CITY OF ALBUQUERQUE

January 5, 2022

Re: EL Encuentro Immigrant Community Center
907 4th Street SW
Traffic Circulation Layout (TCL)
Architect's Stamp 10-15-2021 (K14-D121)

PROPOSED PARKING & TRAFFIC CIRCULATION LAYOUT
 PROPERTY LOT A
 SCALE 1:200

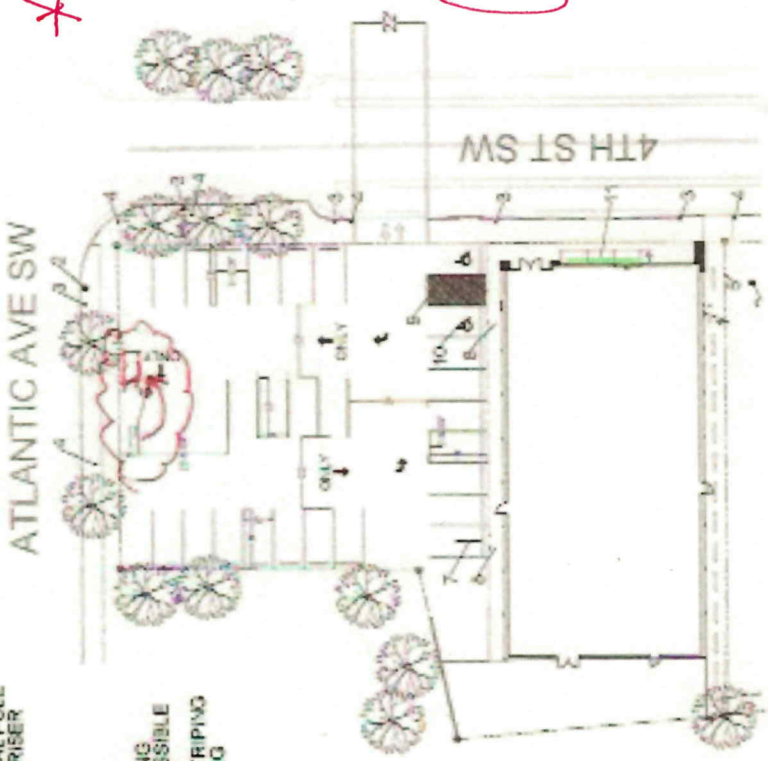
3. The scale must be shown on the plan. Per the Development Process Manual, Chapter 27, Section 2, Part B.1, on the following scales may be used:

- **The ADA parking stall and access aisle are not dimensioned . Please provide dimension to assure requirements are met.**

BICYCLE RACK REQUIREMENTS: 3 BICYCLES
SCALE 1" = 10'

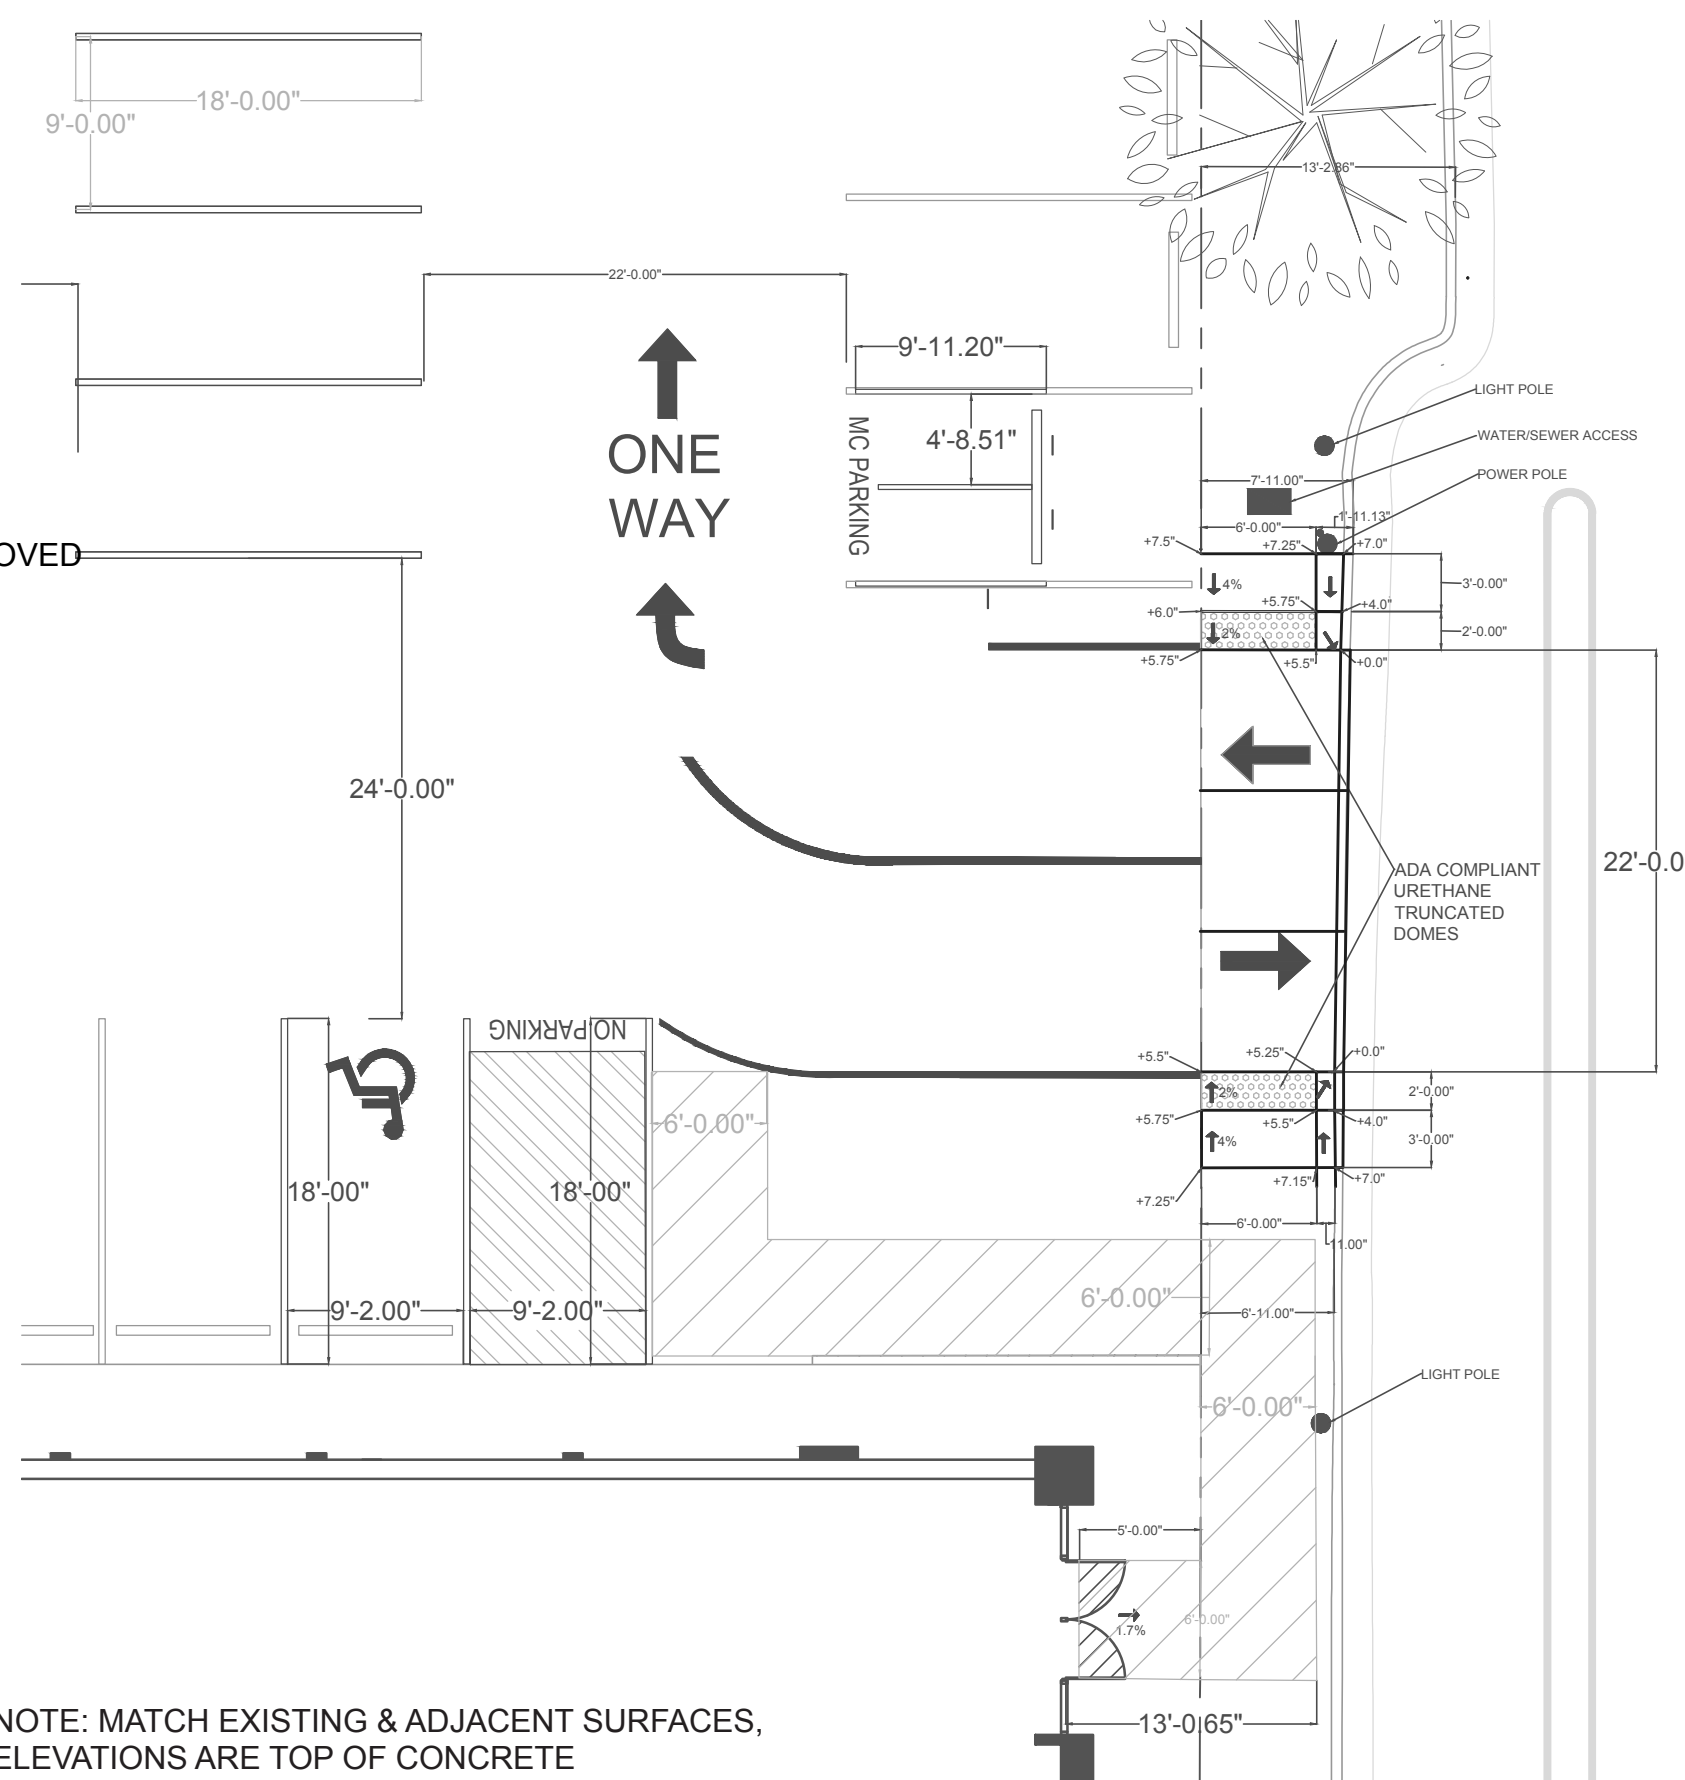
9. **Bicycle Rack requirements:** Provide all details (Attachment E) that comply with bicycle design requirements onto Site Plan.
10. Per the DPM, a 6 ft. wide ADA accessible pedestrian pathway is required from the public sidewalk to the building entrances. Please clearly show this pathway and provide details. **The grades will need to comply with 2% cross slope and longitudinal grade of 5% max. Please add this to the Legend notes for ADA compliant.**

PROPOSED DRIVEWAY- LOT A
SCALE 1" = 10'

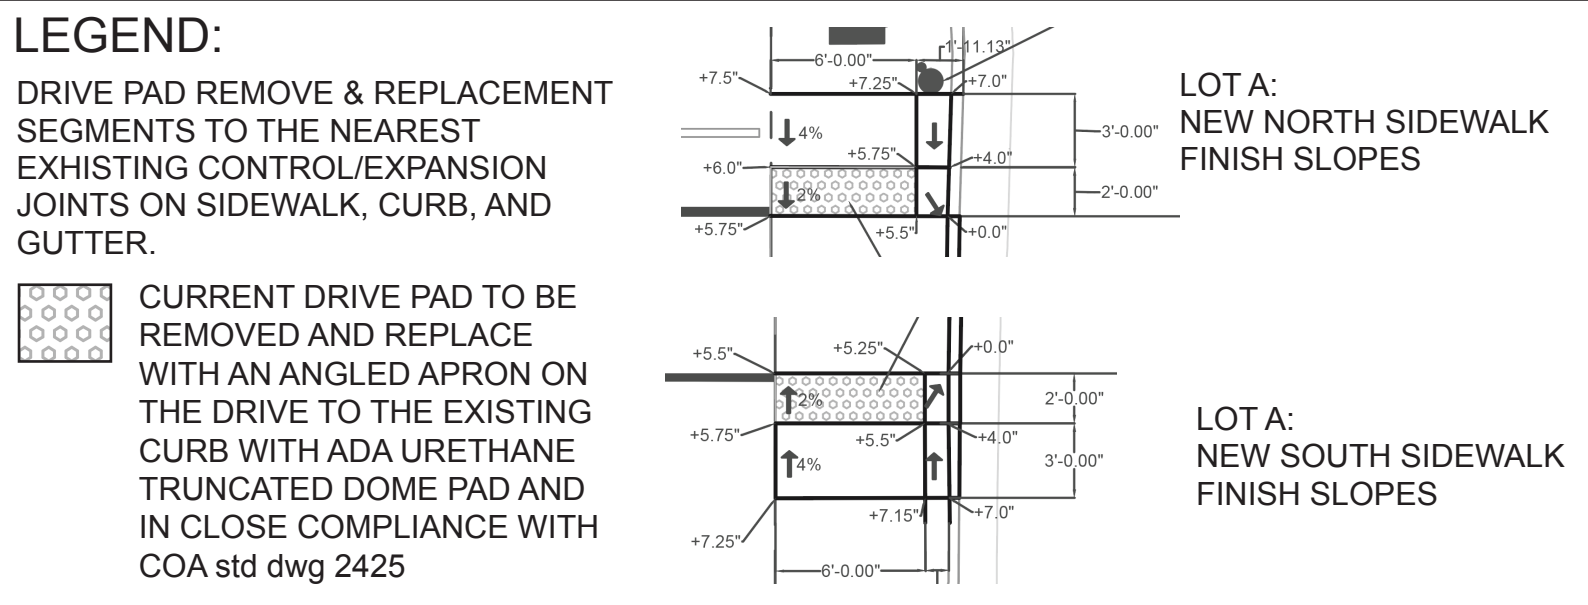
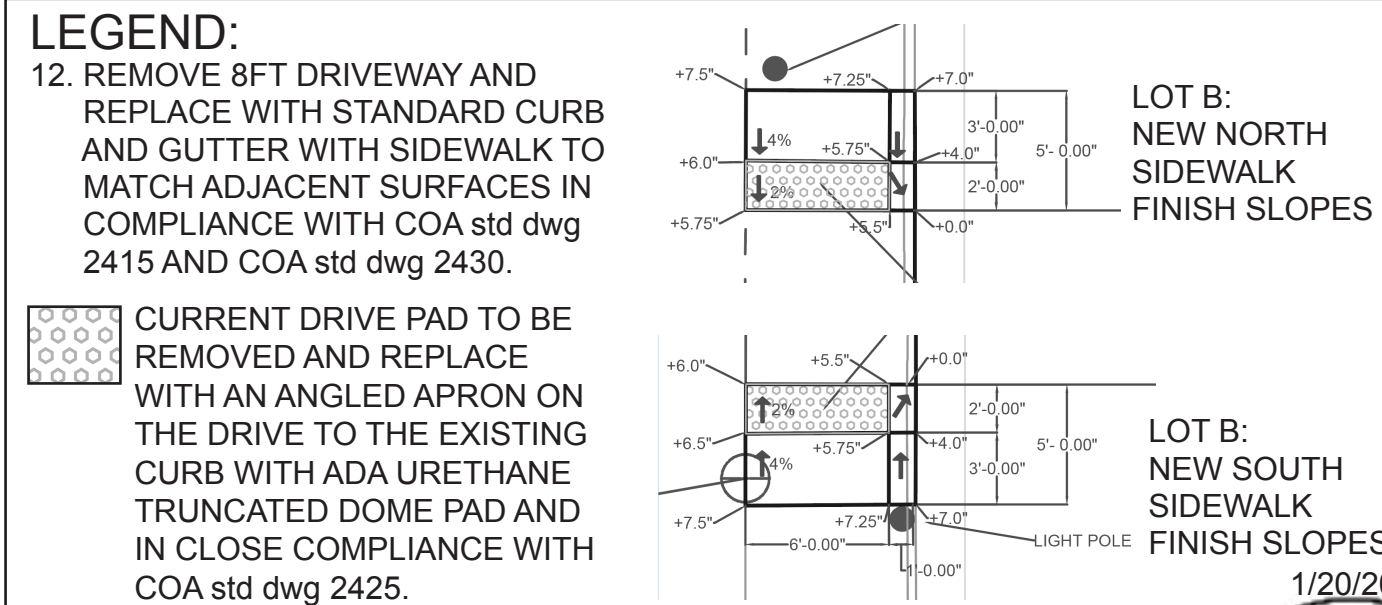
1. Private driverpads entrance off 4th (both):

- You will need to label the driverpads (both) whole segment to be replaced since the proposed hatching shown on plans doesn't show the extend of removal/replacement.
- Call out COA std dwg 2425 instead of COA 2425 because std dwg are references design.
- Remove the diagonal wings off the driverpads since this will conflict with ADA pathway across entrance drive.

EXISTING/ PROPOSED CORNER
SCALE 1" = 10'

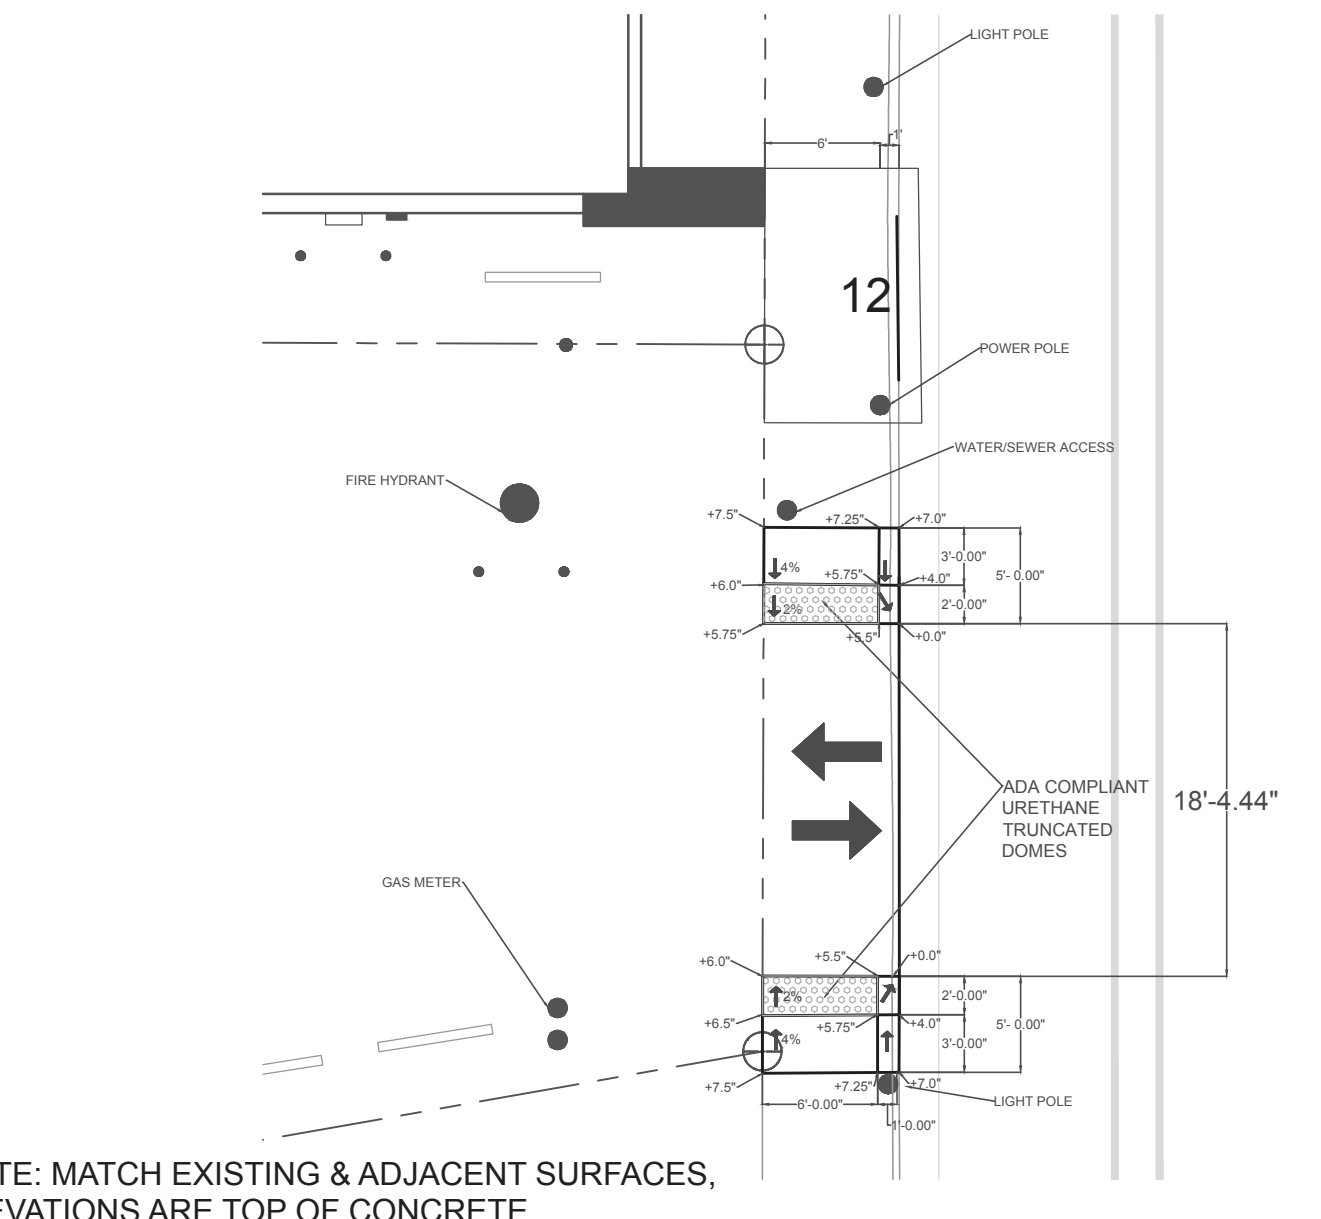
8. ADA curb ramps must be updated to current standards and have truncated domes installed (**Corner of Atlantic/4th**). **Provide a detail for this corner ramp or Reference COA std dwg to substantiate ADA ramp design with detectable warning surfaces . Design needs to include dimensions for ramp slope (12:1 max) and landing (50:1 max). Add these requirements to Proposed Legend notes of ADA compliant Slope.**
